Architectural Design
Saxon End
Bordean
Petersfield
GU32 1EP

Please ask for: Ms Iqraa Malik
Email: iqraa.malik@terraquest.co.uk
Telephone: 0121 234 1390
Our Ref: AL/133/21/HH
Your Ref:
Date: 30th November 2021

Application for Planning Permission for Works or Extension to a Dwelling

Development: Erection of single storey rear extension.
Location: Mellotron 8 Dukes Road Fontwell BN18 0SP

BLOCK/SITE PLAN
AREA 90m x 90m
SCALE 1:500 on A4
CENTRE COORDINATES: 494687, 107575

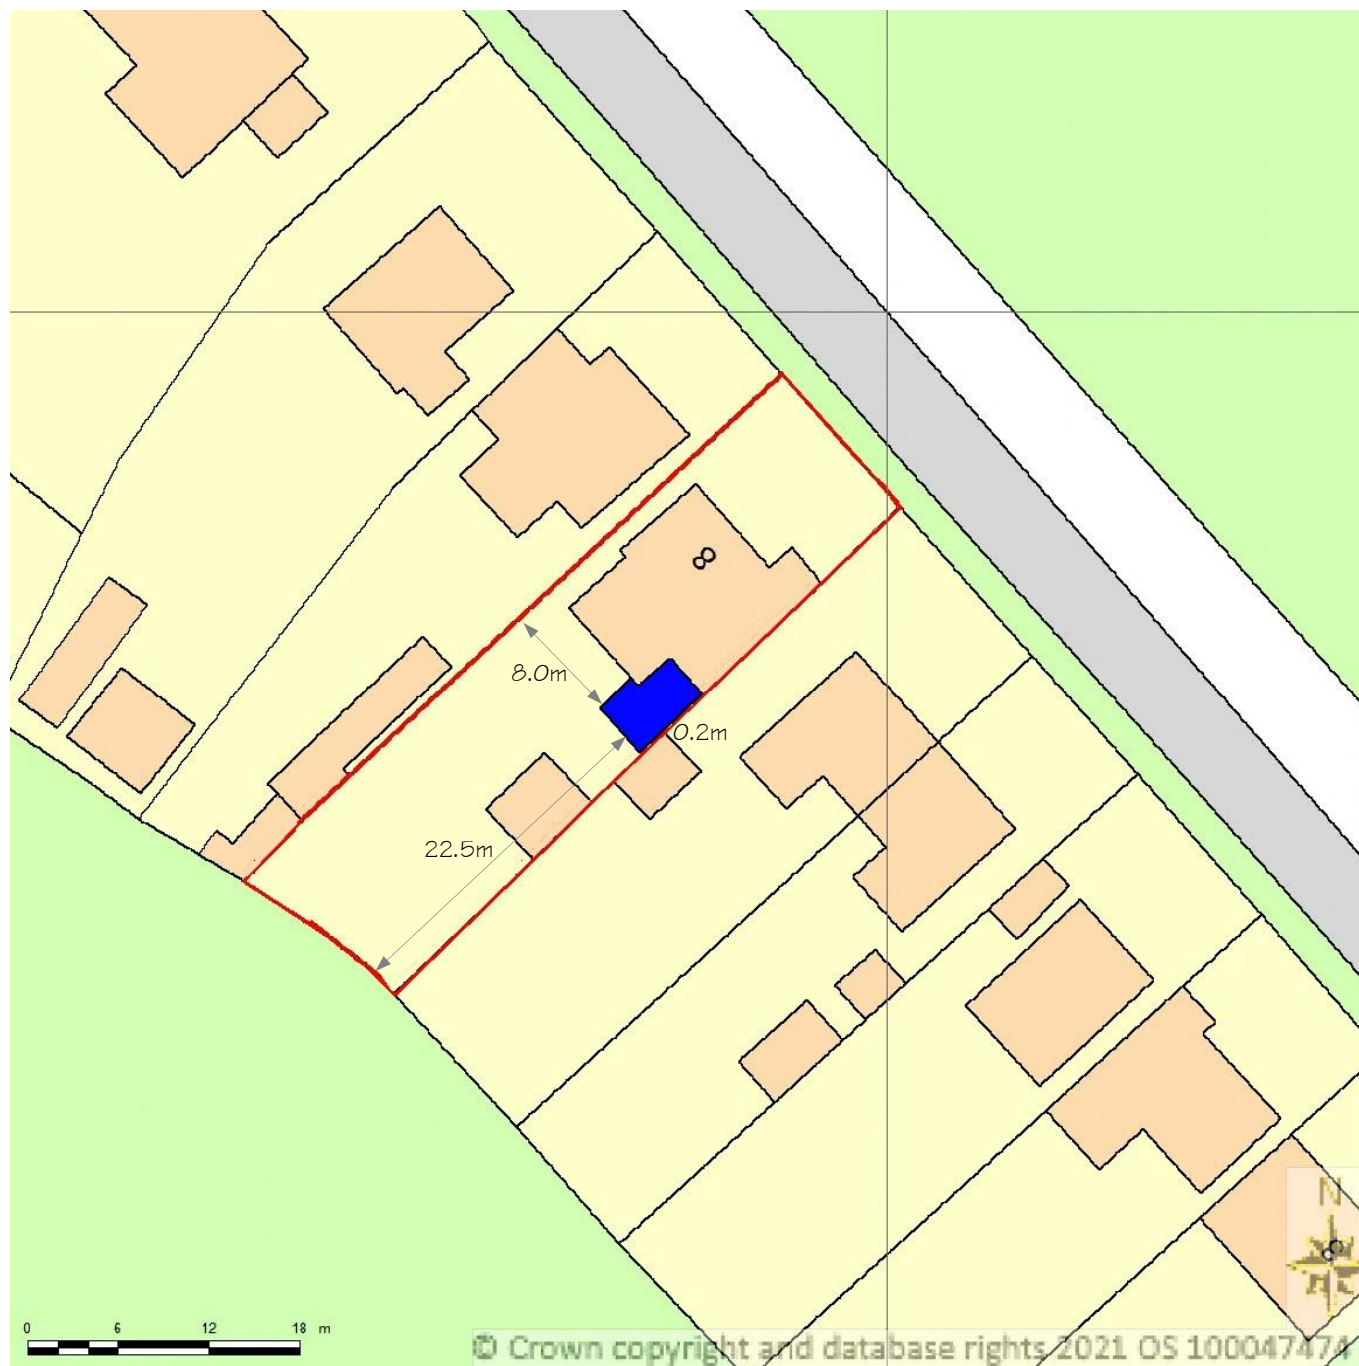
Block Plan

You are required to have dimensions from the proposed extension(s) to all site boundaries. Please amend.

Drawing
COPYRIGHT ©
EXISTING ELEVATIONS

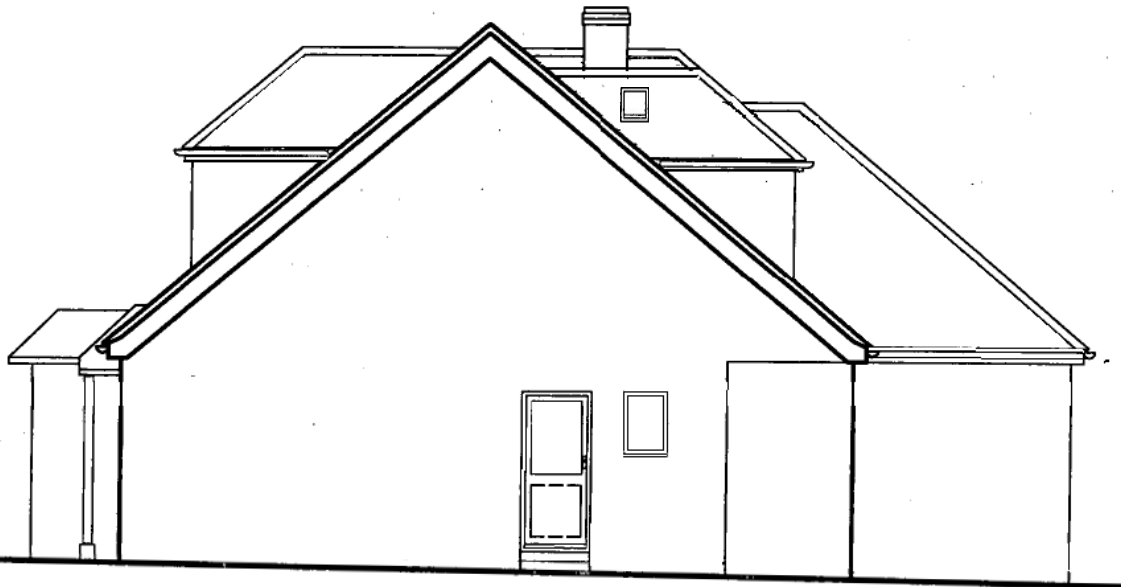
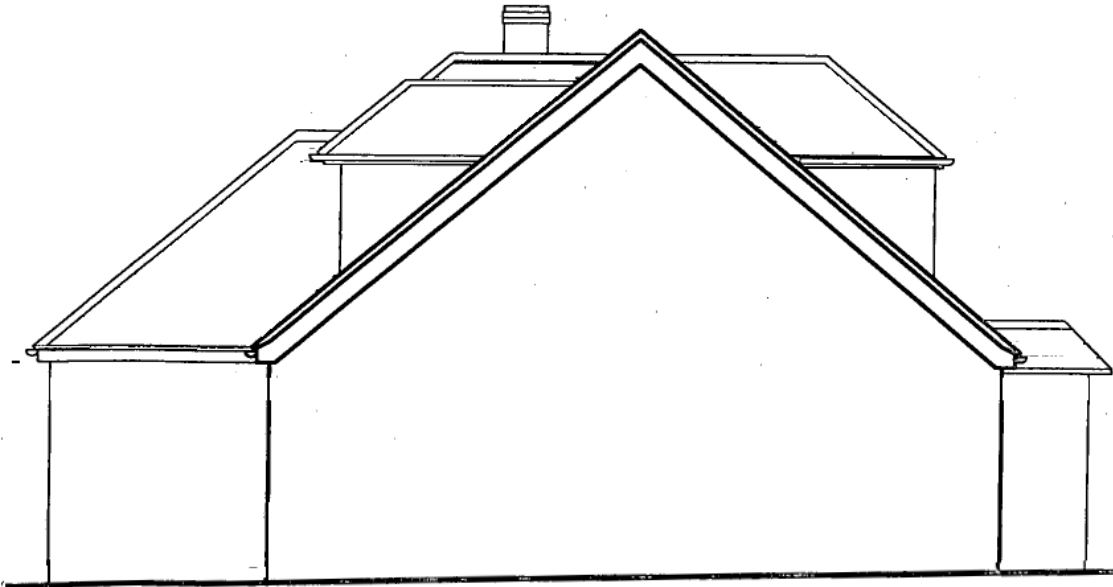
Elevations

The existing and proposed side elevations are labelled as front and the rear elevations are labelled as side. Please review and amend.
